7 November 2017

File No: 2017/556954

State Significant Development application for the Inner Sydney High School (SSD 7610) – Response to Submissions

title
Sun Studies
June 21st - 204-214 Chalmers St Facade

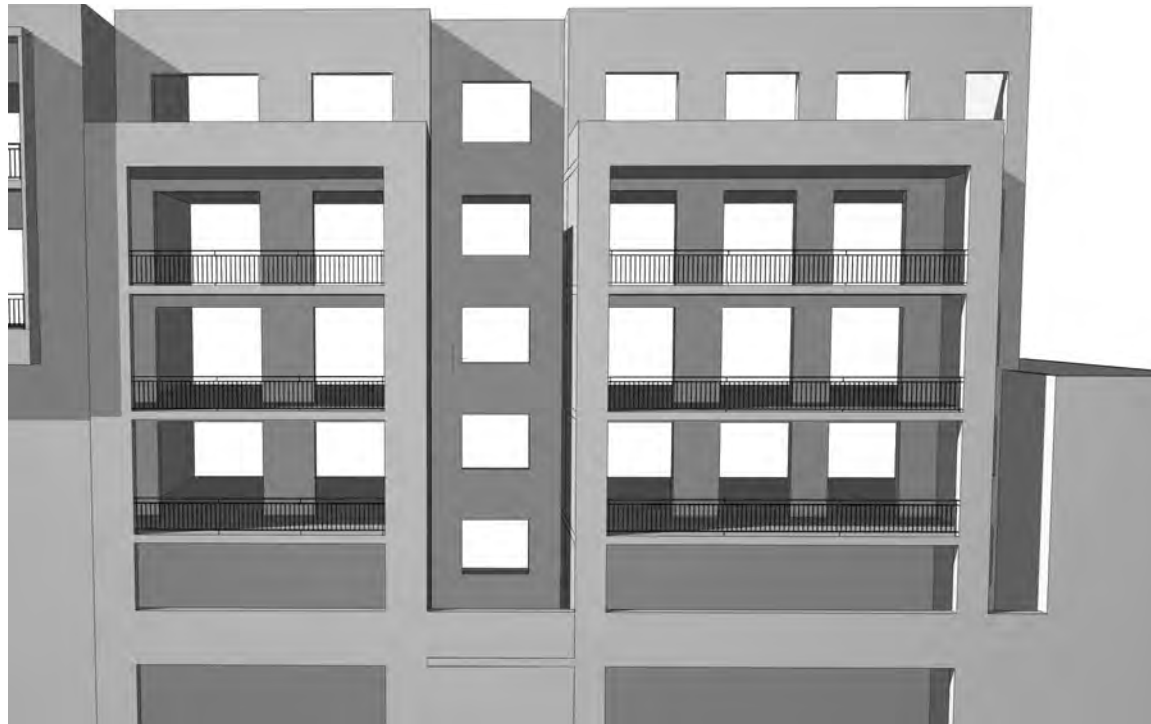
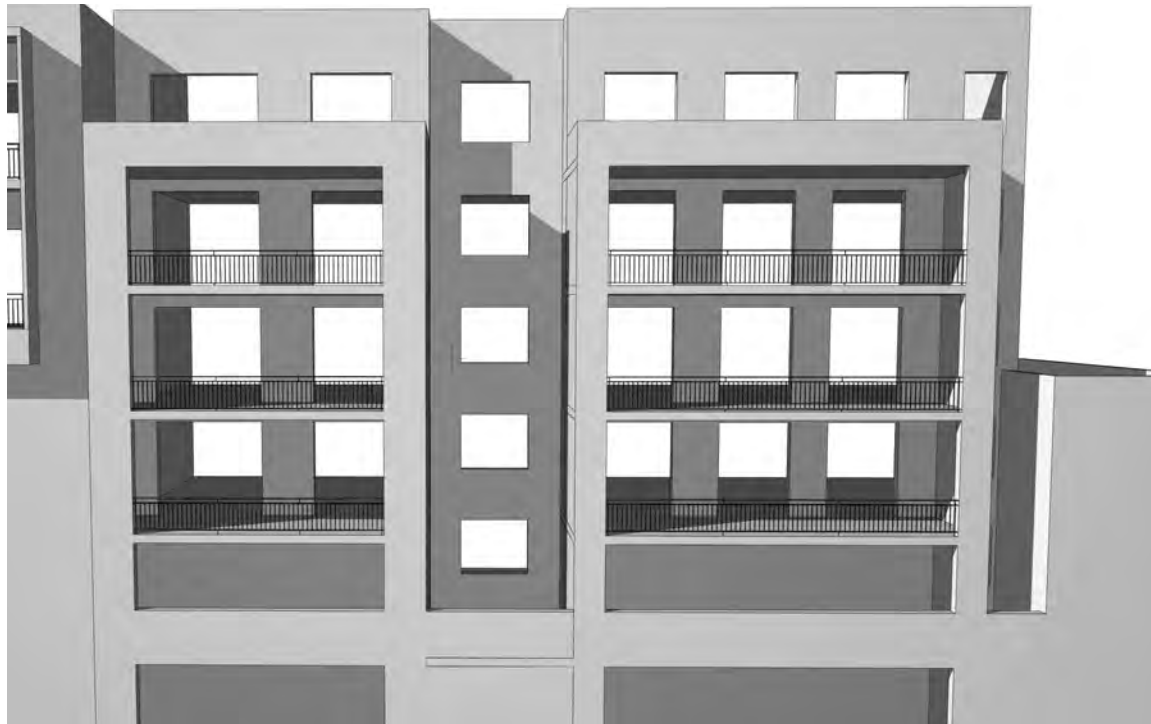
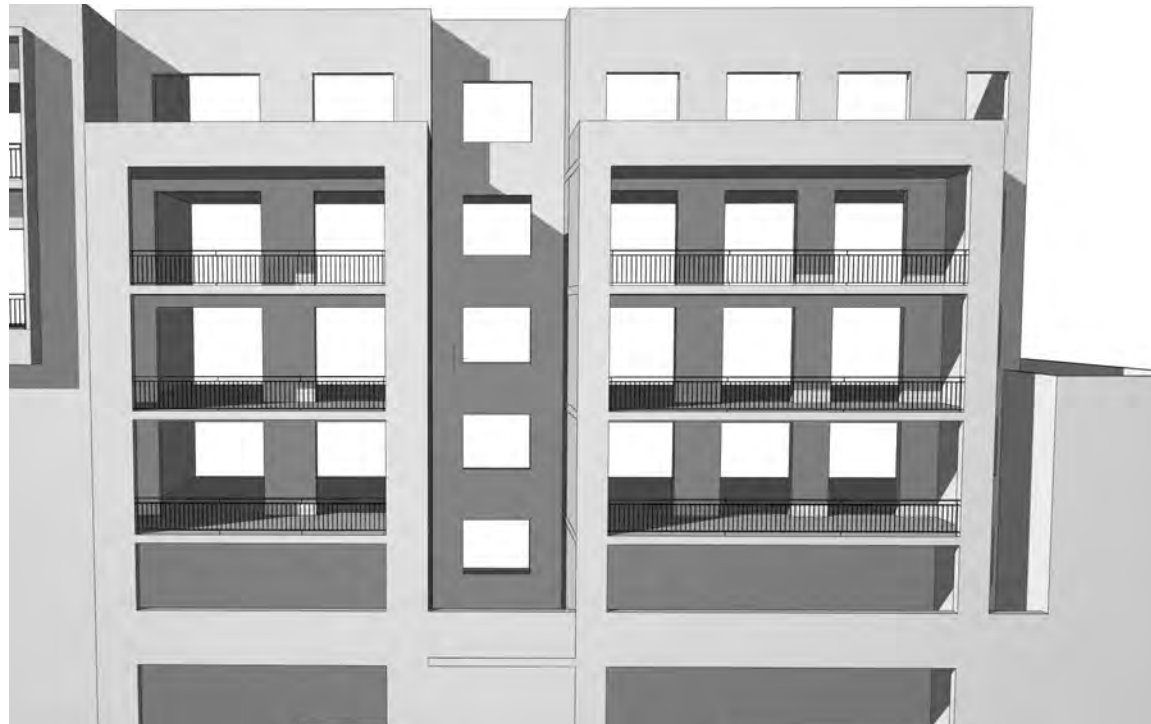
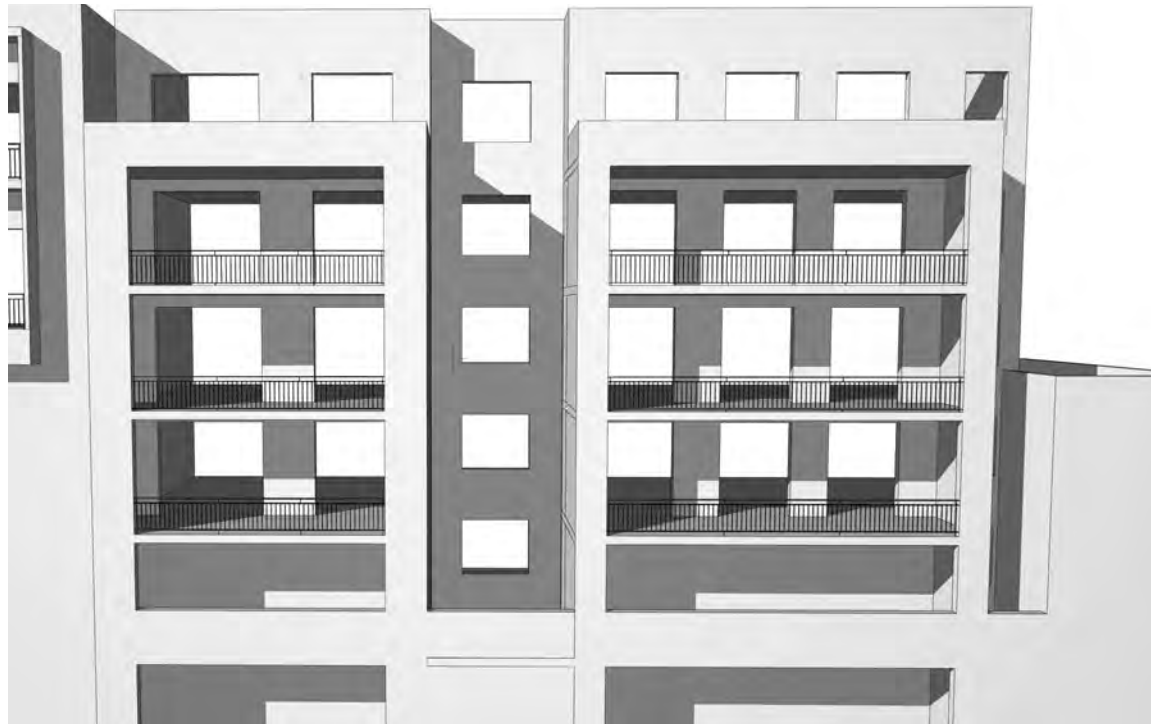
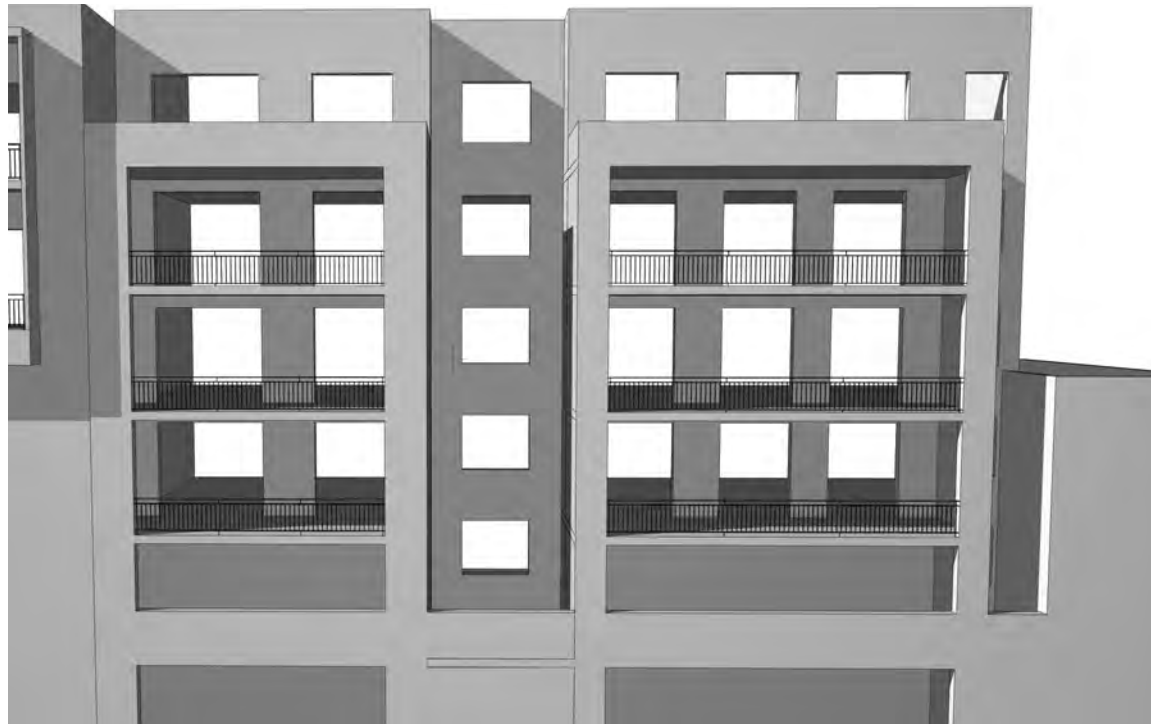
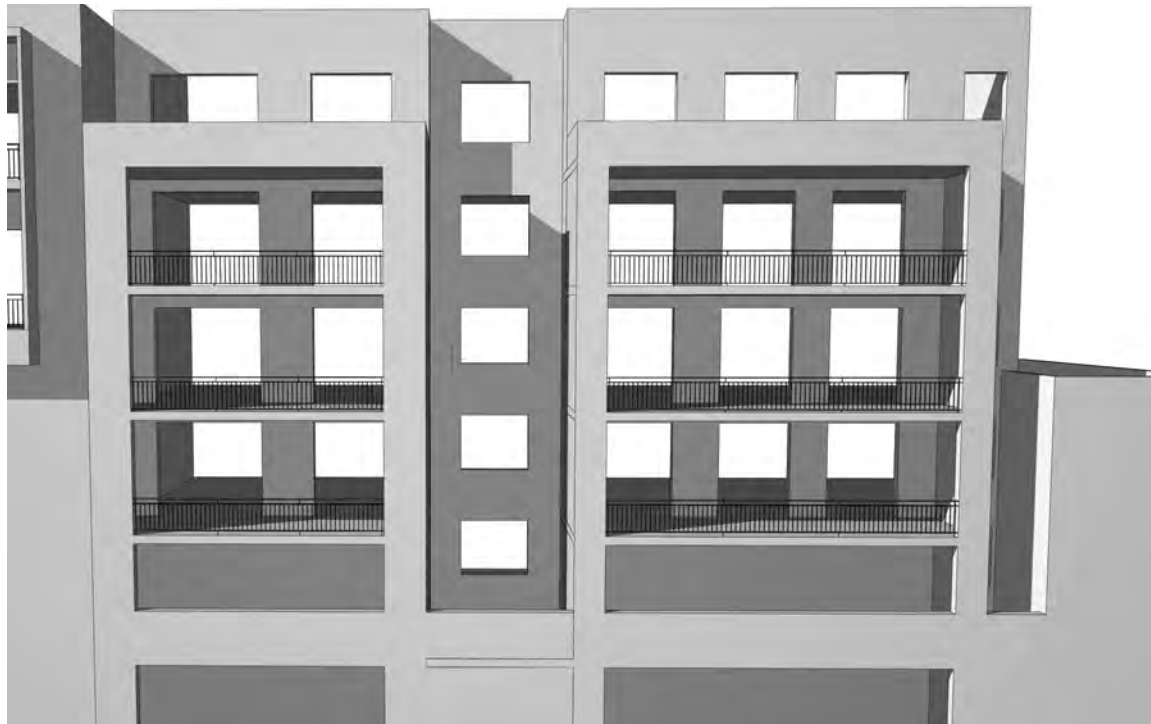
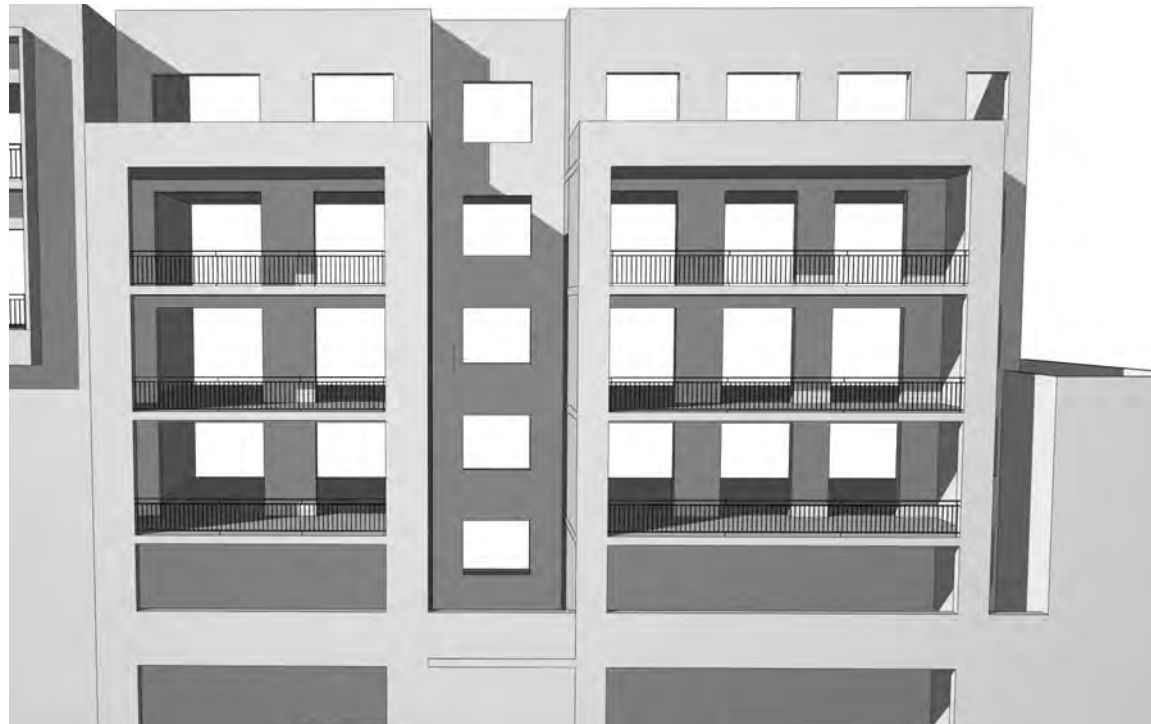
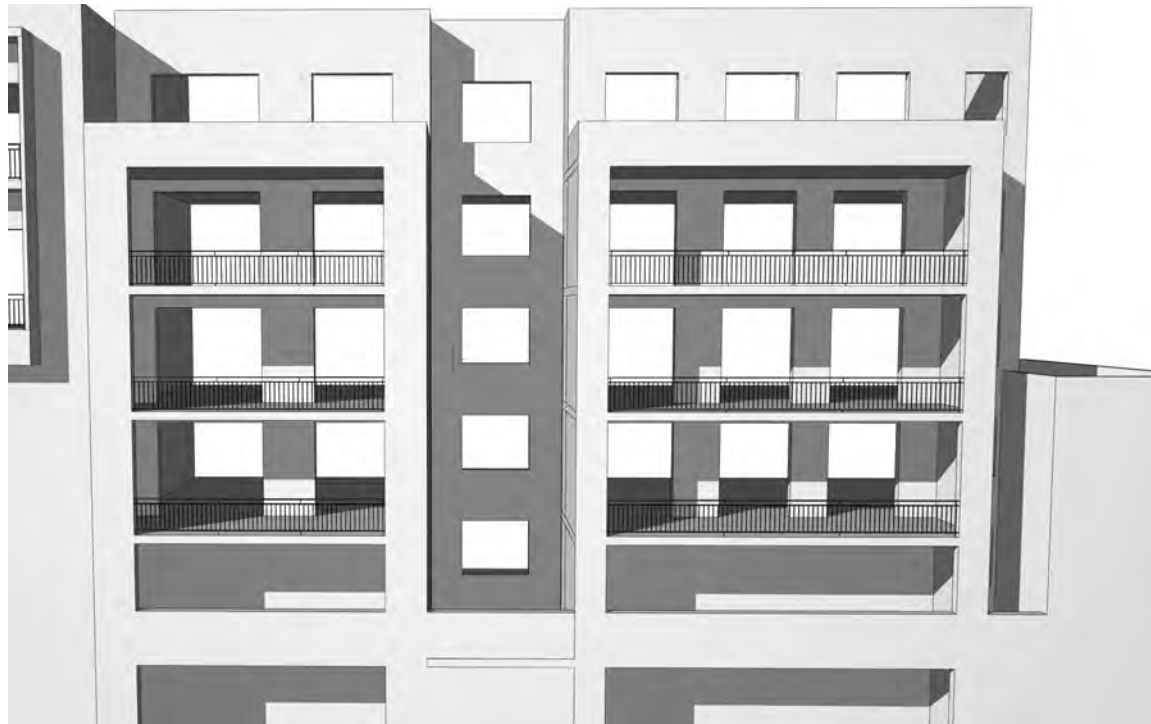
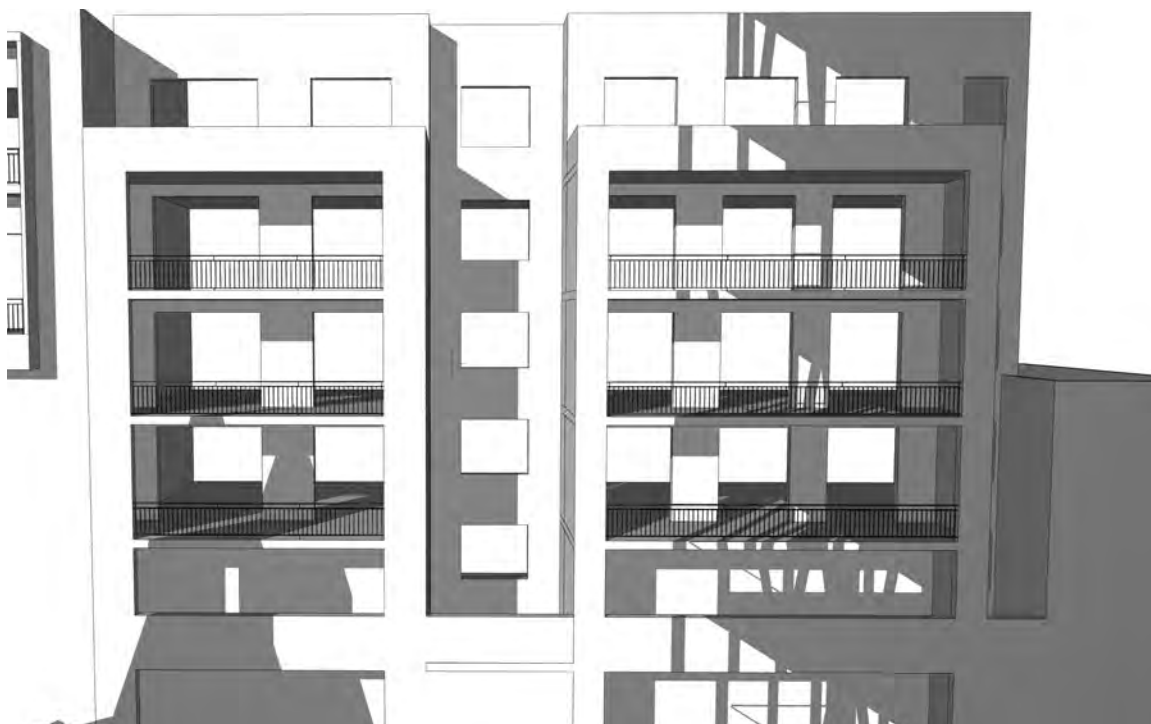
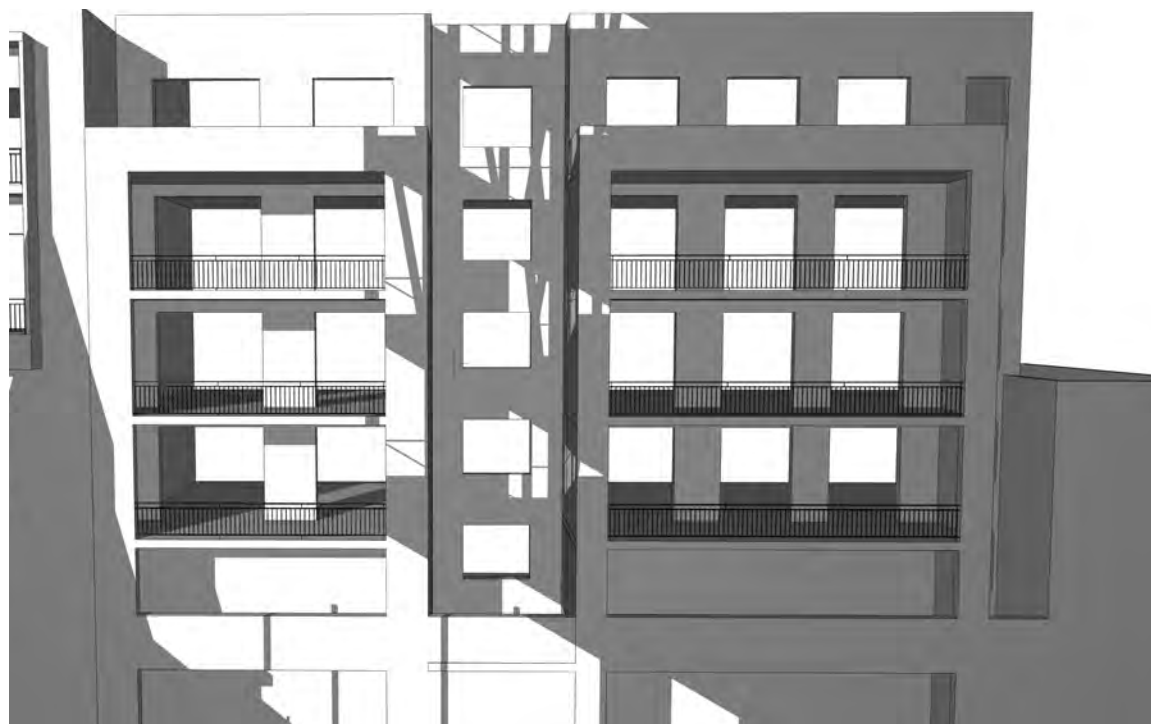
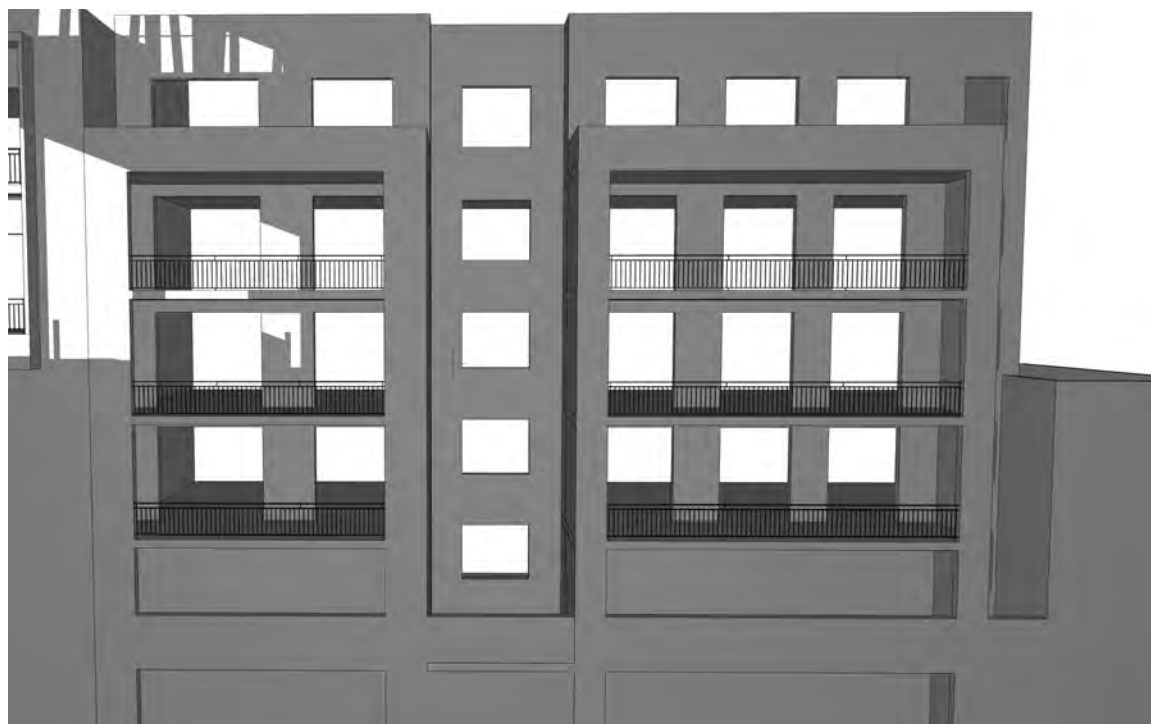
In the proposed condition, the material submitted shows that solar access is lost at 3pm. This impacts two apartments each at level 1 and 2, and 1 apartment at levels 3, 4, and 5. Without the half hour views, it is not possible to conclude whether these 7 apartments change from a complying to non-complying status. The Department should satisfy itself whether the reduction in sunlight hours results in a solar access non-compliance or not, and whether the resultant amenity is acceptable.
